Application No: FG/94/20/HH
Site Address: 7 Little Drive Ferring BN12 5RF
Description of works: Conversion of roofspace to habitable use and conversion of roof from hip to gable end and single storey rear extension.

Thank you for your internet representation made on 24th August 2020 which has been recorded as an objection with the comments as follows:

For • Mr. & Mrs. K. King
D.R.G. • 19/14/3.A.
SCALE : 1/50. A.2019.
DATE : DEC. 2019.

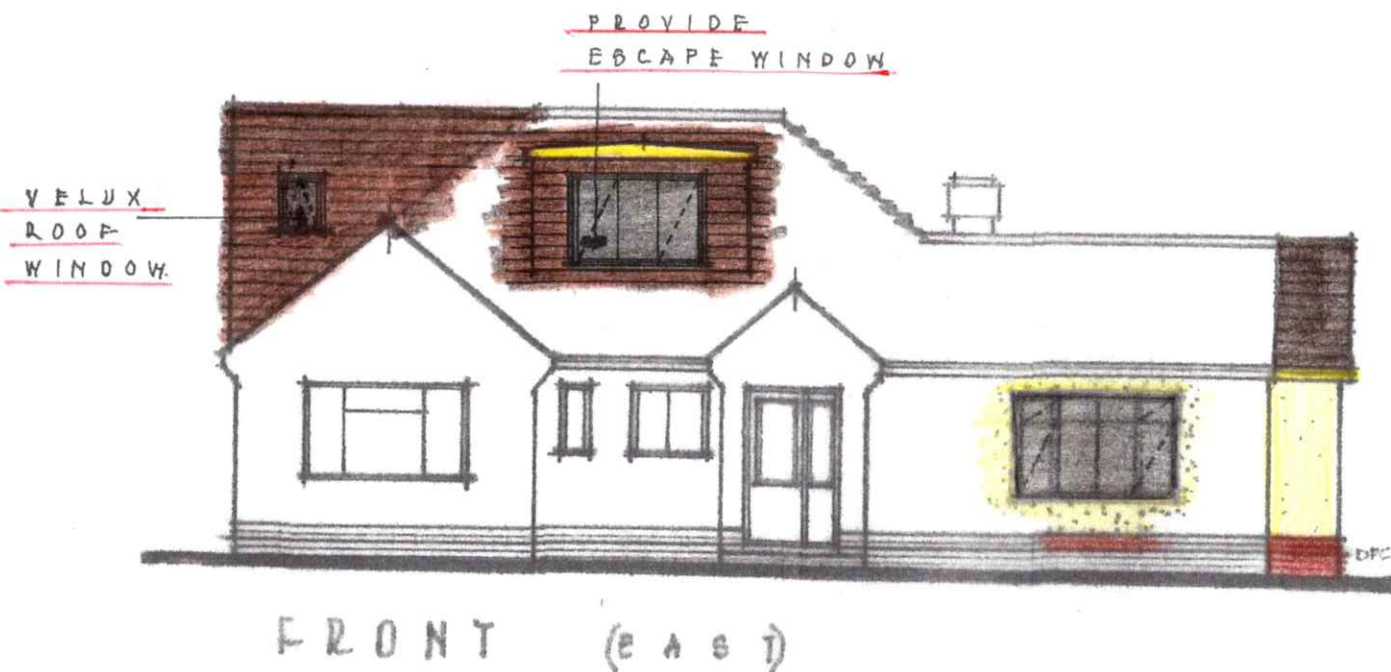
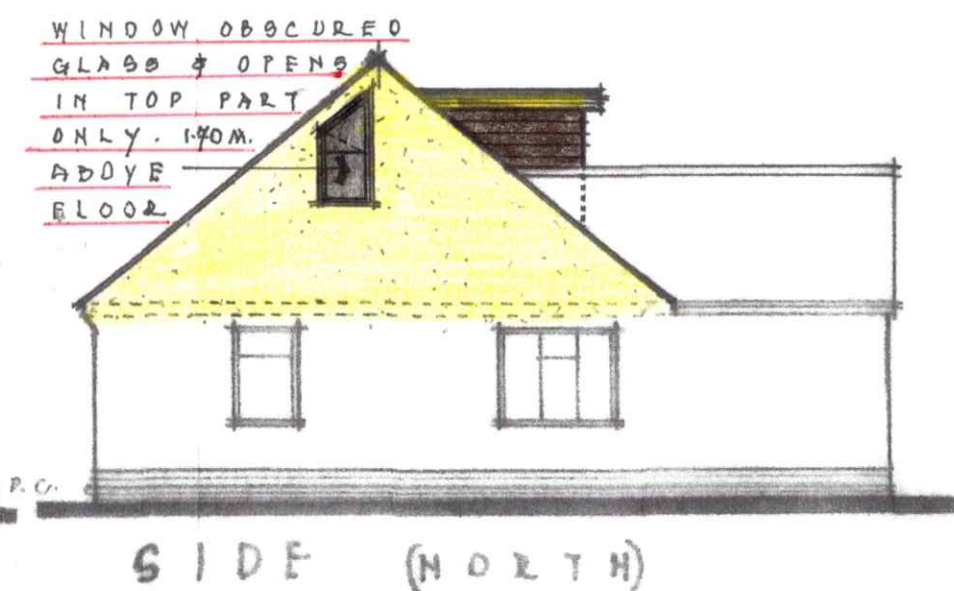
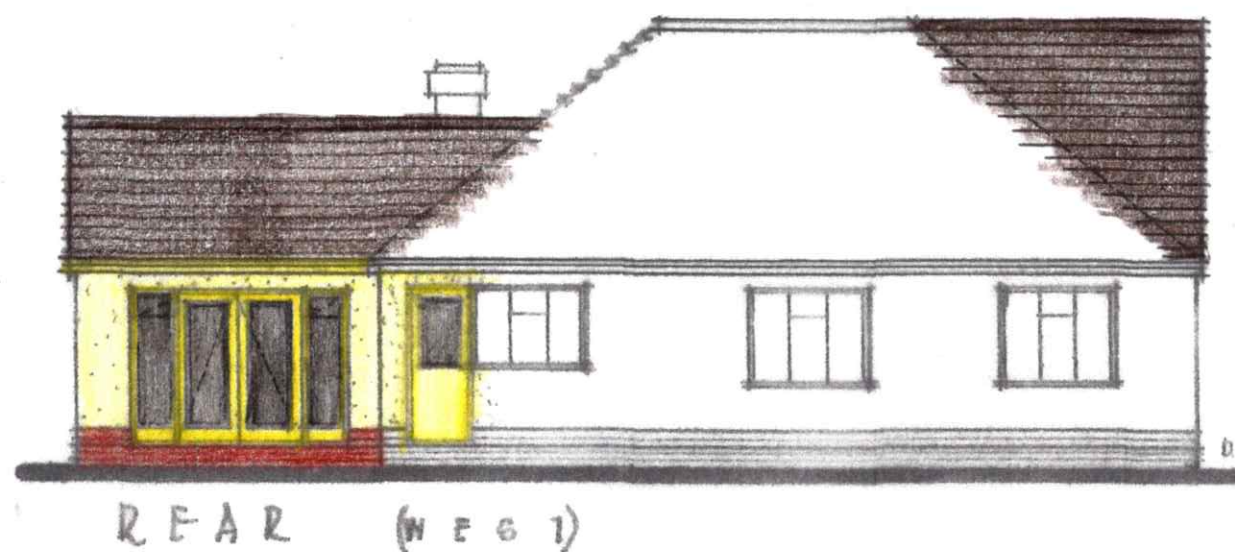
We have examined the plans submitted and would now like to formally object to the planning application of number 7 Little Drive due to the fact that the dormer in the front of the property is a direct invasion of our privacy.

We live at 11 Little Drive which sits on a corner plot positioned in front of number 7 Little Drive. The dormer will look directly into our back garden leaving no area where our family will be allowed any privacy; it also has direct sight into the master bedroom window and my daughter's bedroom requiring blinds to be drawn to maintain privacy and incurring a loss of light as a result. The front dormer will also peer directly into our side lounge window and is completely out of character for all neighbouring and adjacent bungalows in Little Drive.

We have lived in Little Drive for over five years and are aware there is a covenant on the bungalows which includes number 7, that does not allow windows being put into the roof. No other bungalows in Little Drive have put in dormer windows in their roof which significantly overlook and invade another bungalows privacy in this cul de sac, especially one that overlooks a neighbouring property to all primary aspects of their property, as it would do to 11 Little Drive.

In conclusion, when we bought this home to raise our two daughters, we chose it because it was very private from being overlooked due to the fact that it was surrounded by bungalows. The loft conversion with the use of dormers being proposed at 7 Little Drive removes all of our privacy and changes the way my family live, therefore we strongly object to the planning application FG/94/20/HH.
